City of Portland, Maine – Building or Use Permit Application 389 Congress Street, 04101, Tel: (207) 874-8703, FAX: 874-8716

Proposed Project Description: Change roof pitch (Gable end to face street. move location of gas fireplace, window modifications. Lot 25						
Permit Taken By: Chris		Date Applied For: 3/07/2001		CIN		Zoning Appeal <input type="checkbox"/> Variance <input type="checkbox"/> Miscellaneous <input type="checkbox"/> Conditional Use <input type="checkbox"/> Interpretation <input type="checkbox"/> Approved <input type="checkbox"/> Denied

LOCATION 46 Wyoming AVE. CBL: 400-A-044

Date	11.22.01
Scale	1/4"
Drawn	
Job	
Sheet	1
ELEVATIONS

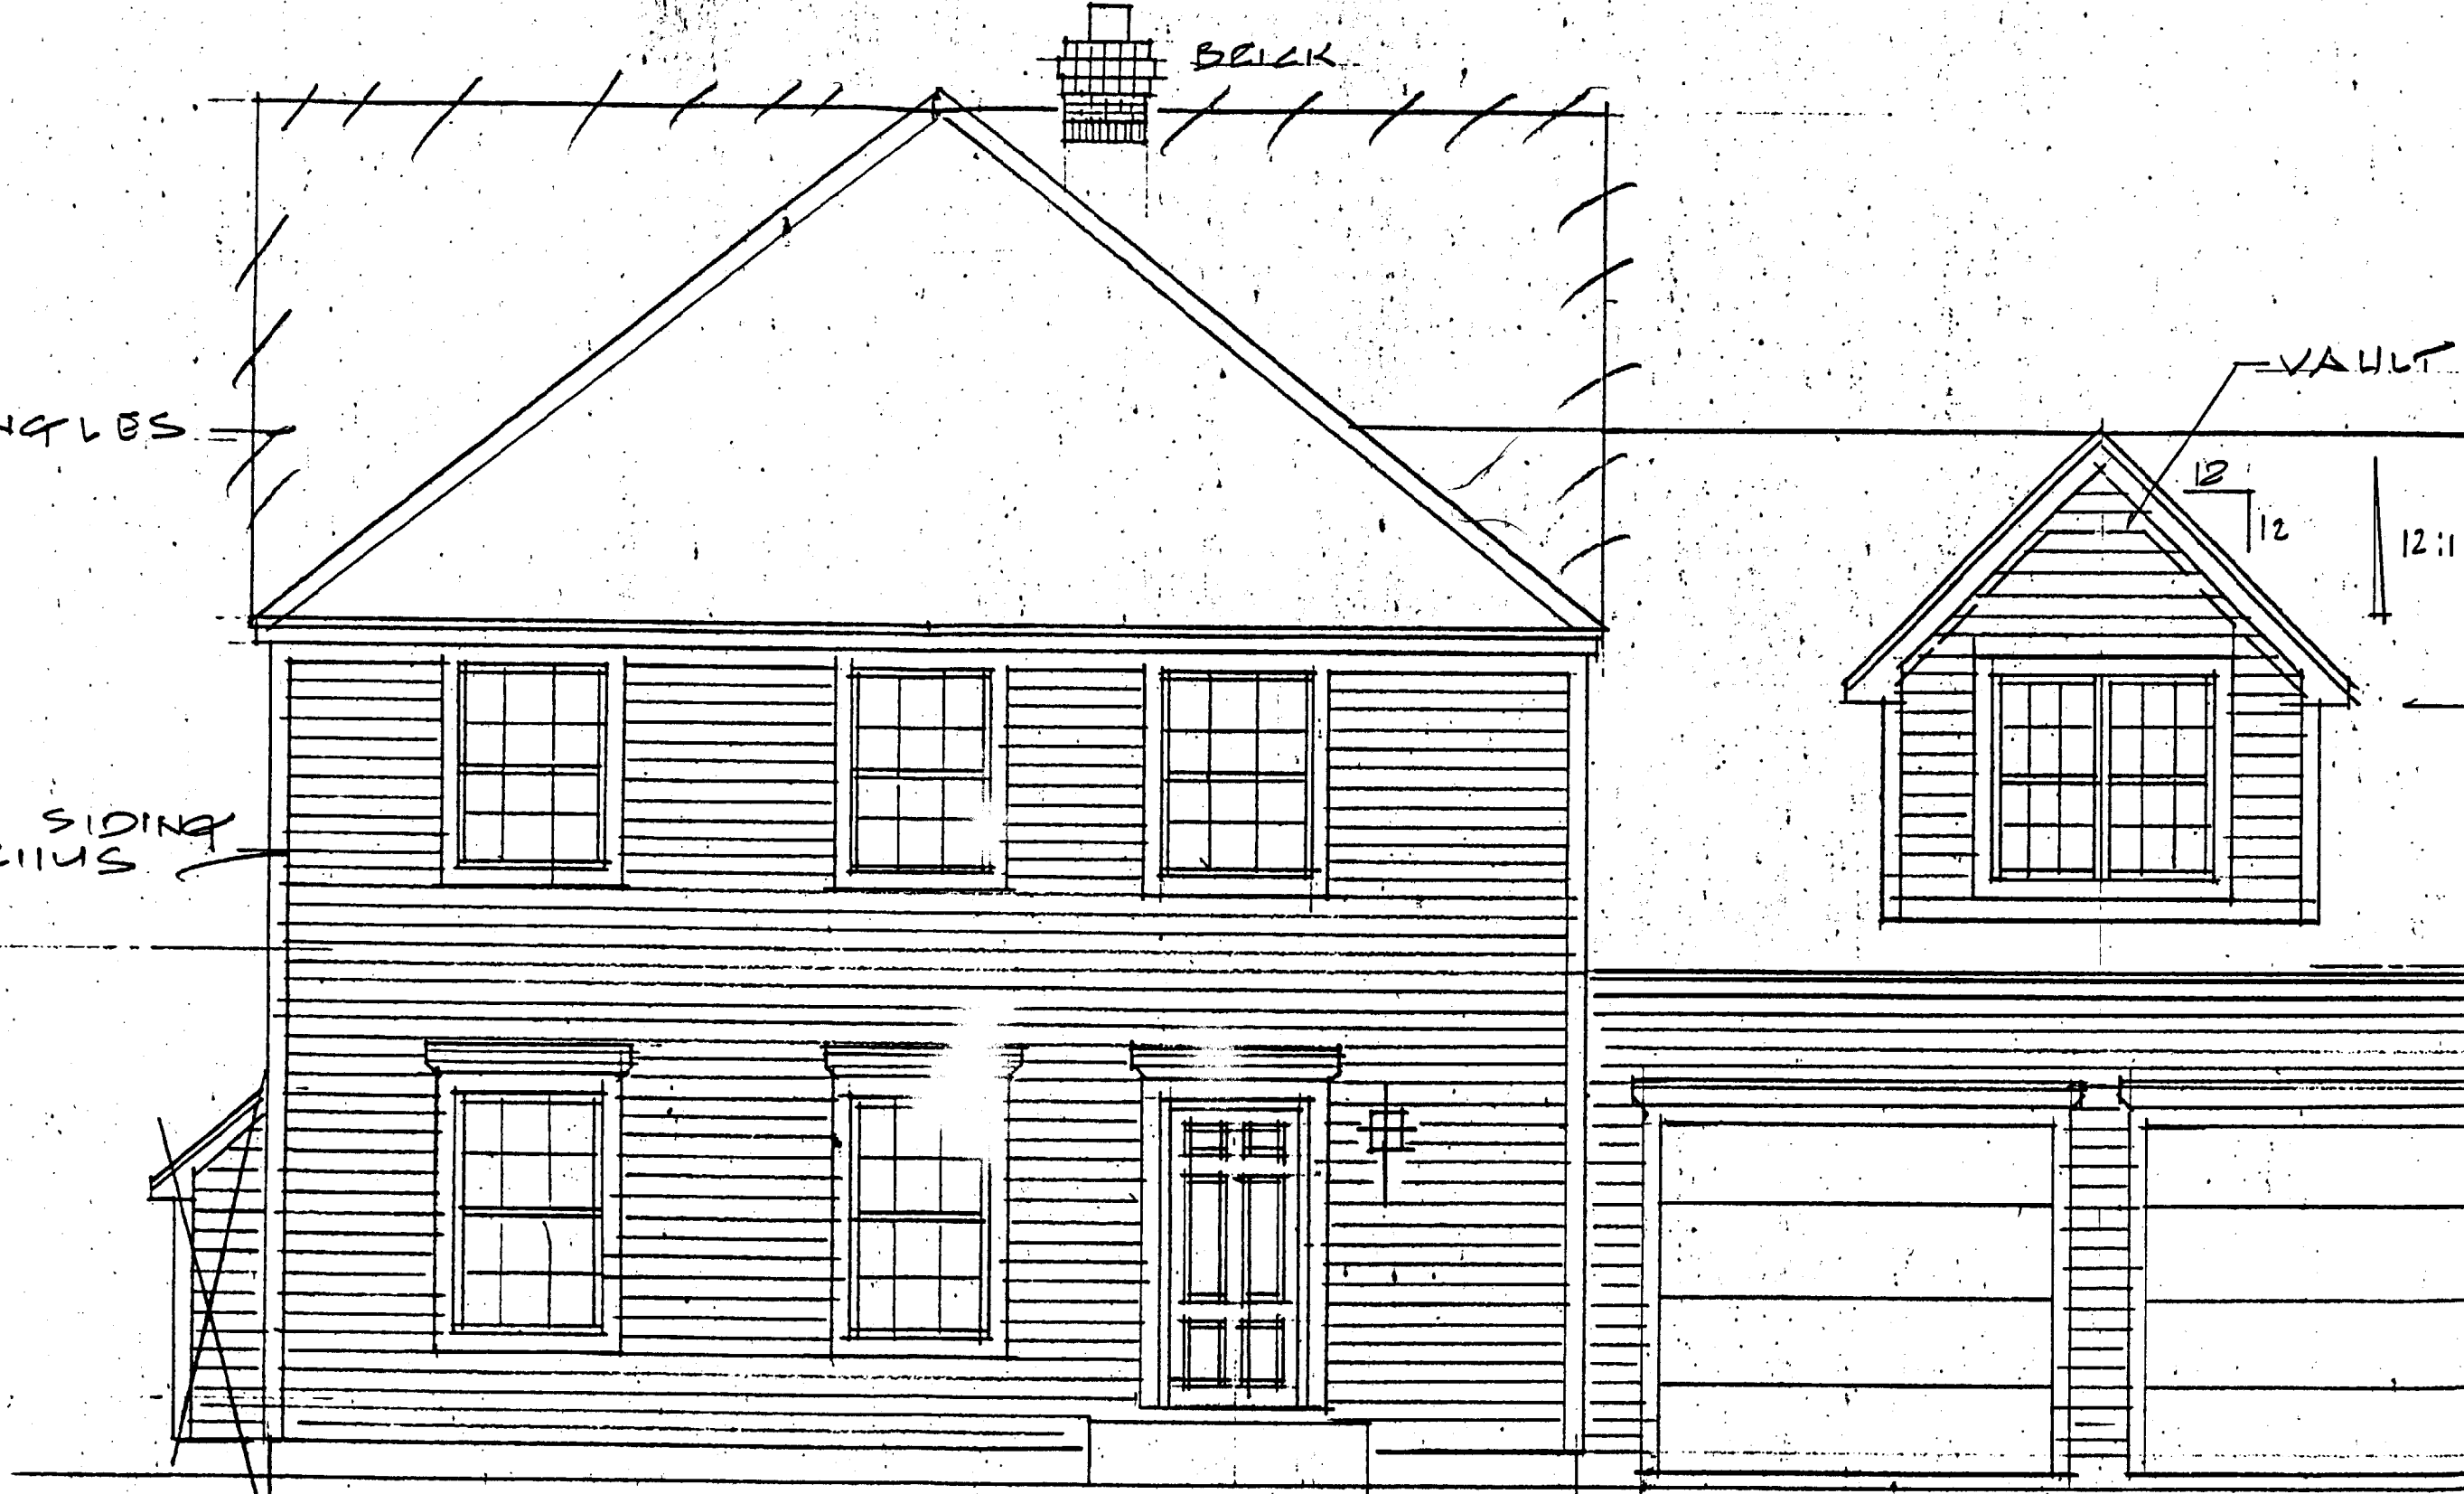
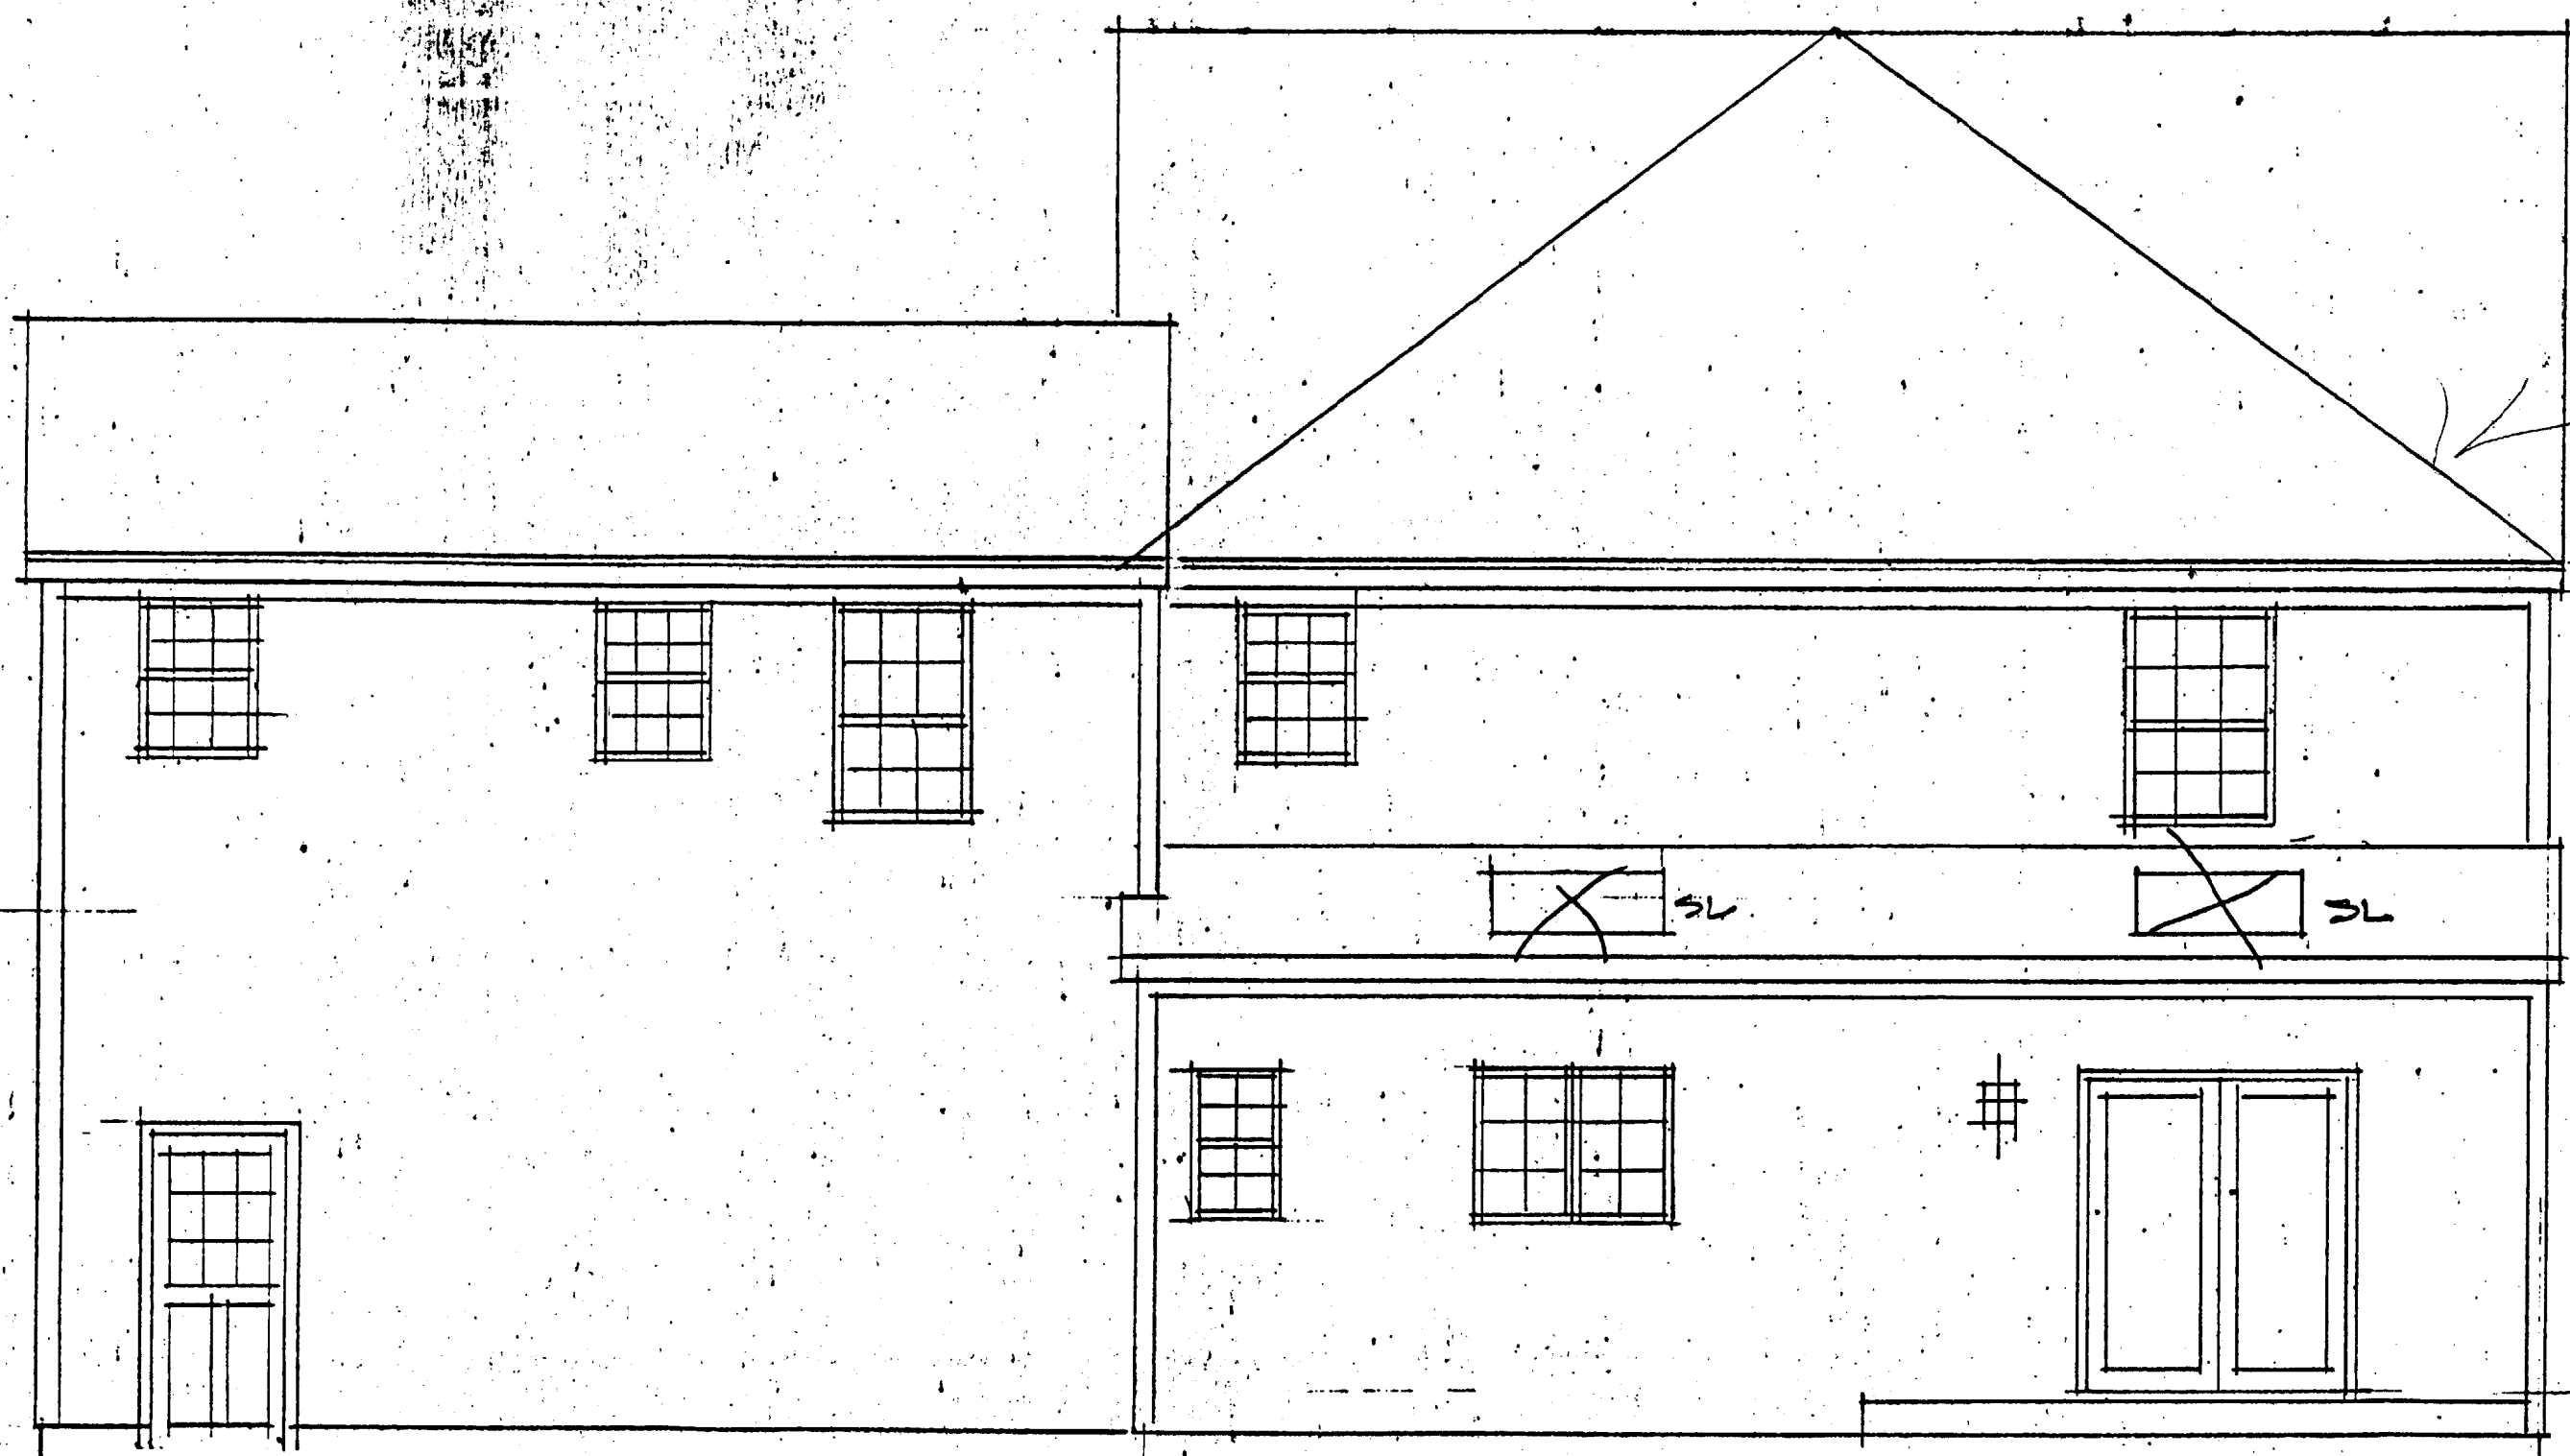
- 3/27/01 Detail needed in wall beside refrigerator - wire next to front Door (2 impd) - needs Blocking on Box (4 gang) - need flashing around chimney - Simplex receptacle needed in upstairs bathroom - Egress windows in Bedroom (= 5.67 (24.75 x 33 = 144) need 5.7 cubic ft - This was largest window measured - Hangers needed near basement stairs - Hangers need in Basement various areas - *Note: steel beam 14" x 18" spanning 30' need specs and bearing requirement. ^{need} Plates protecting plumbing. JB

- 3/29/01 Sam inspected Beam support & w/Engineer's advice added support as indicated on plans - ok to close JB
- 6-11-01: Final for C of O Failed, Missing @ Deck stairs, 8 1/4" Riser @ Main Stairs to 2nd fl. Oak to Carpet, Elect @ Island; Pig. 116^w/TR

RIGHT ELEVATION

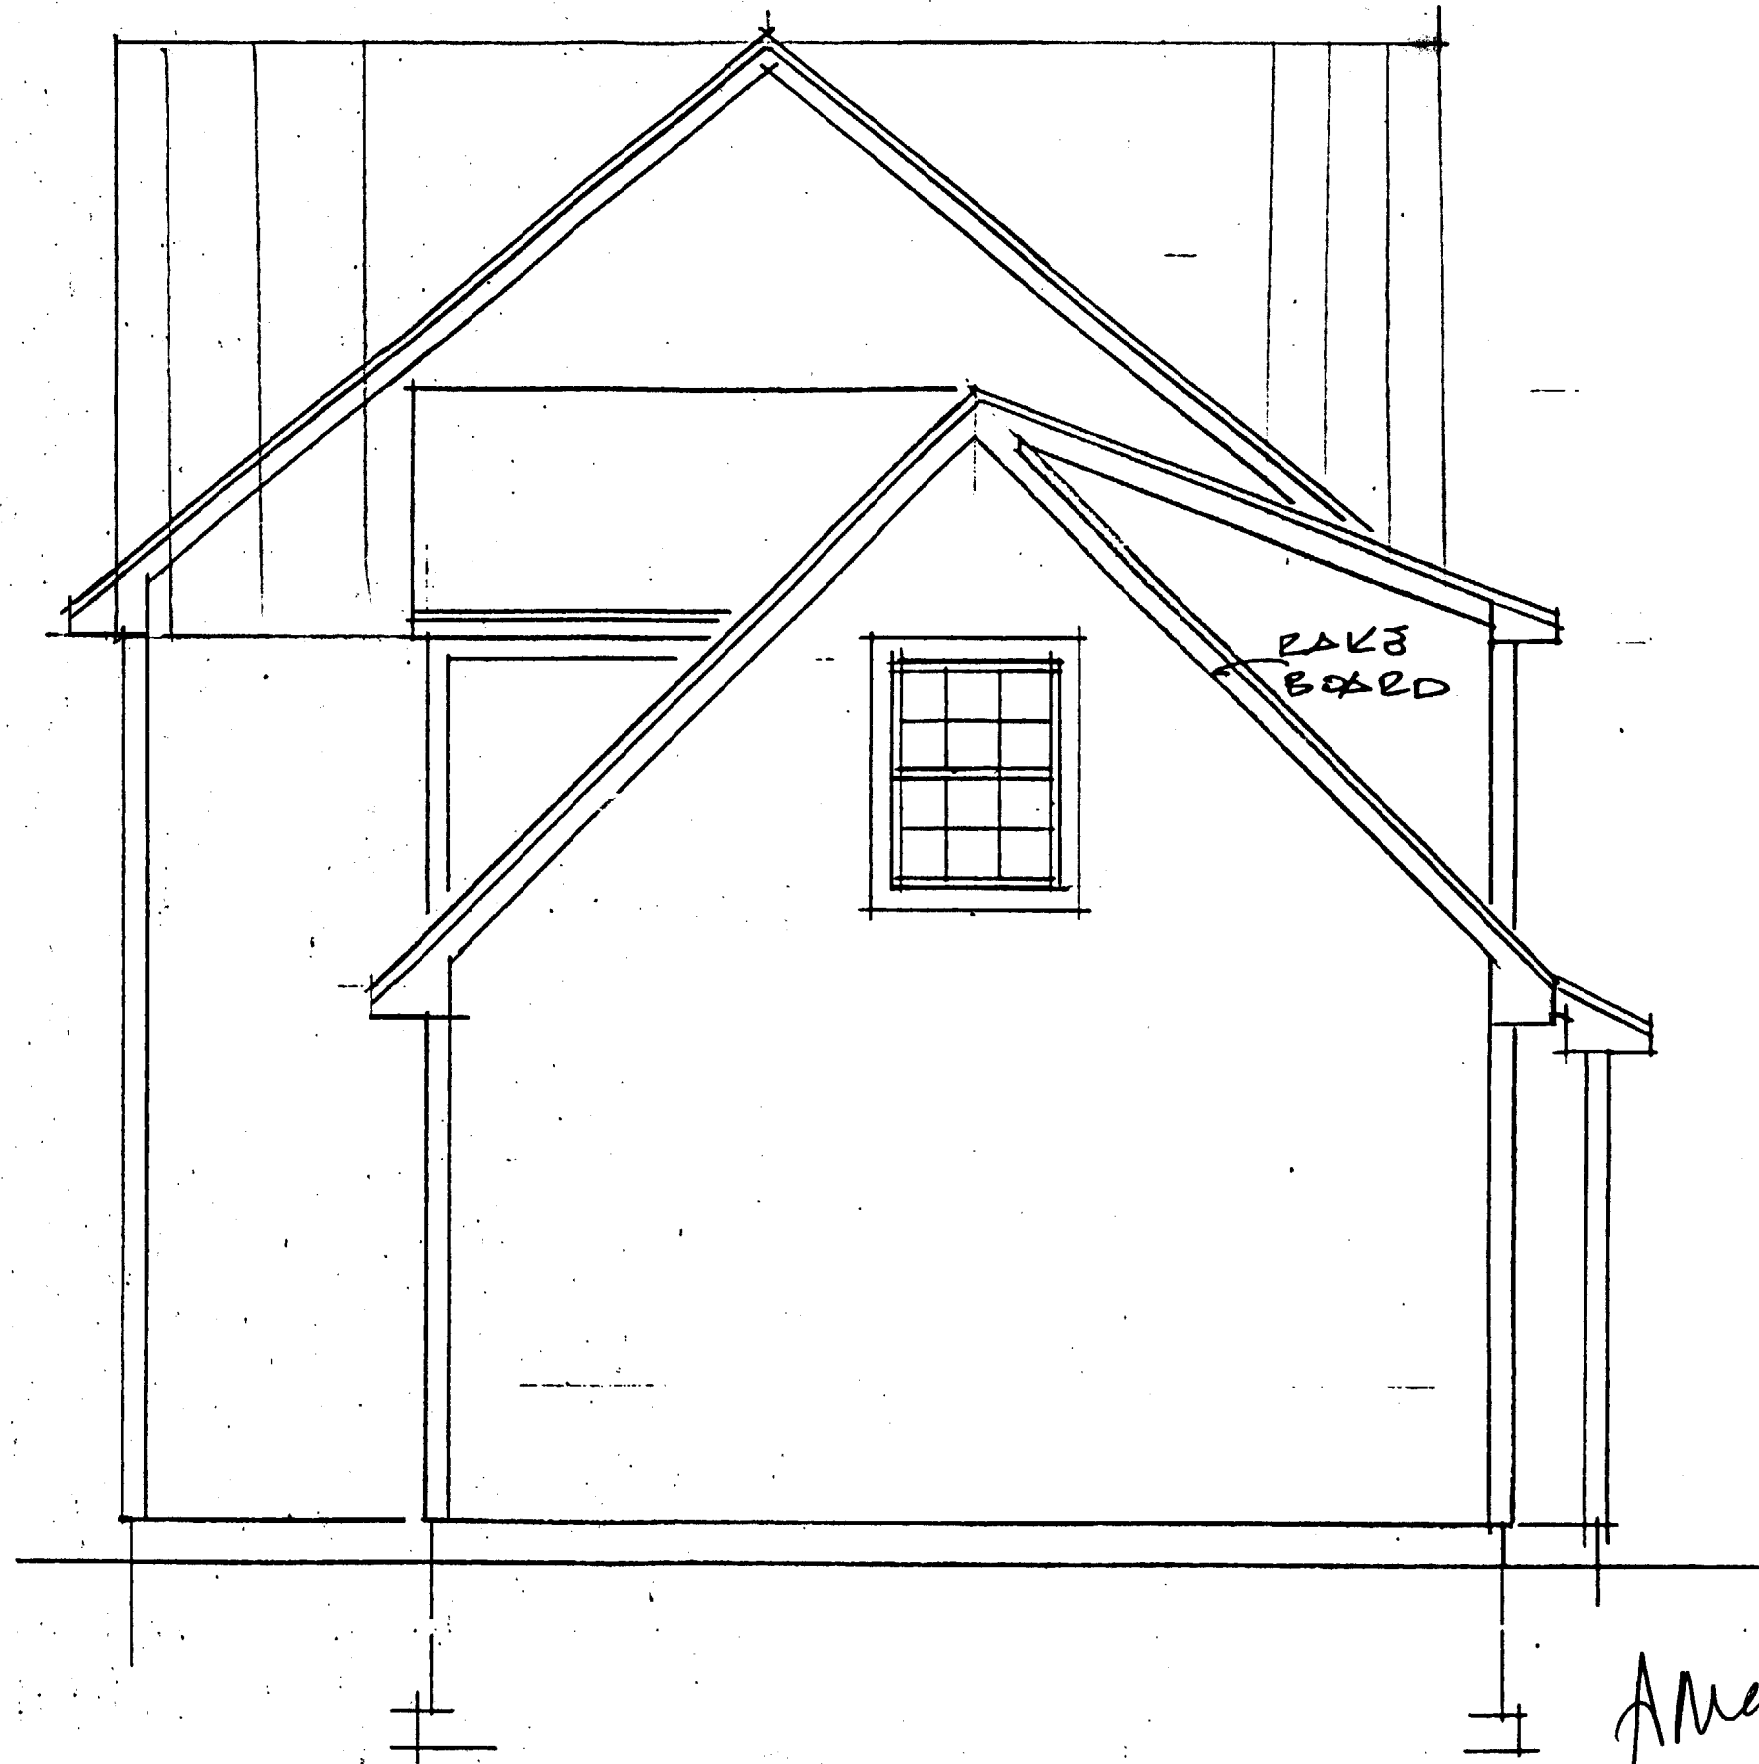
- 3-12-01 Apoke with Greg McCormick - Asked to Fax left side Elevation Showing Foundation detail for daylight basement for measurement of height JB
- 3/13/01 Received Daylight Basement submission from Greg McCormick. Elevation Showing Foundation cut out for windows. Called Greg to verify Footing and wall goes 4" below grade at window cut-out. JB
